Some very significant concerns about the East Park Energy proposals are still unresolved. As well as areas that remain undefined, they have also made substantial changes to the scheme from the one initially submitted, all at a very late stage of the examination.

Status
DCO Application

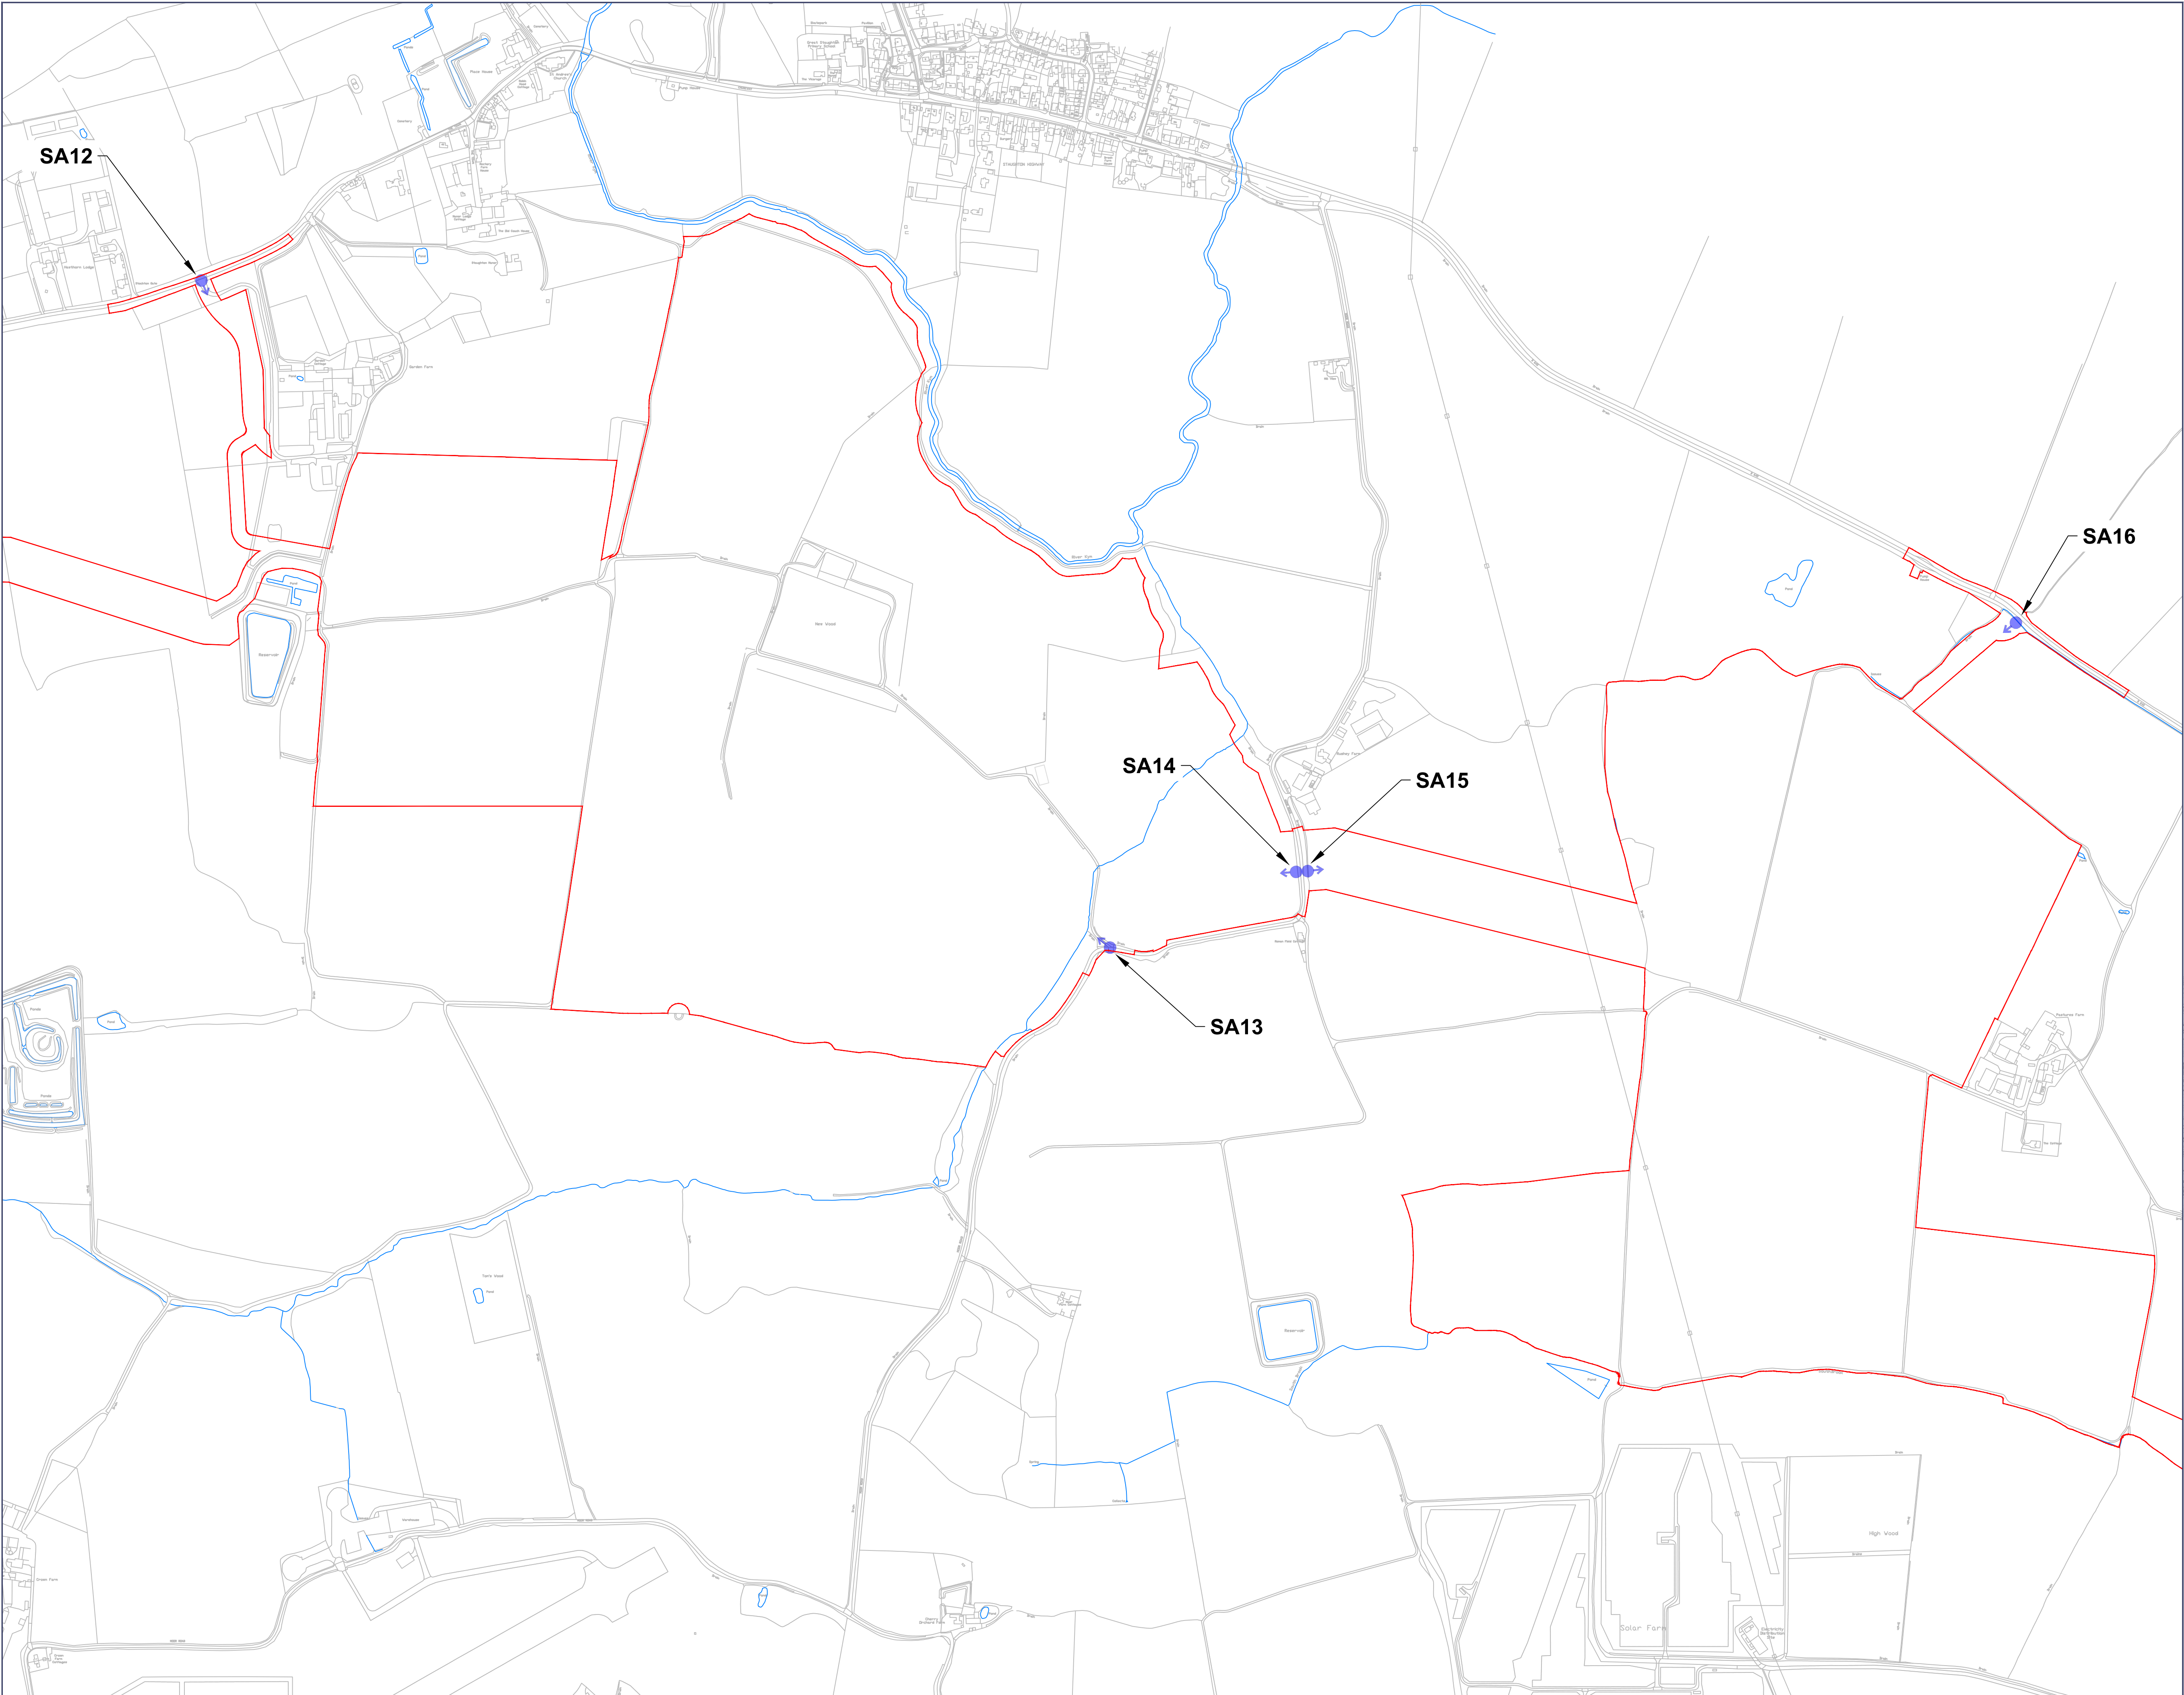
- Their proposed single-point site entrance for both HGV and staff vehicles remains non-mandatory and without any detail of enforcement regimes or even management plans. Despite their statements that narrow country lanes will not be used, there are still multiple site access points shown on these roads.
- There are significant errors in the estimated number of HGV movements which have not been satisfactorily addressed by the Applicant.
- There are doubts about the effectiveness of the proposed carsharing /minibus use as a voluntary method of reducing workforce traffic. The site plans still show car parking areas at every site with no detailed traffic management plans.
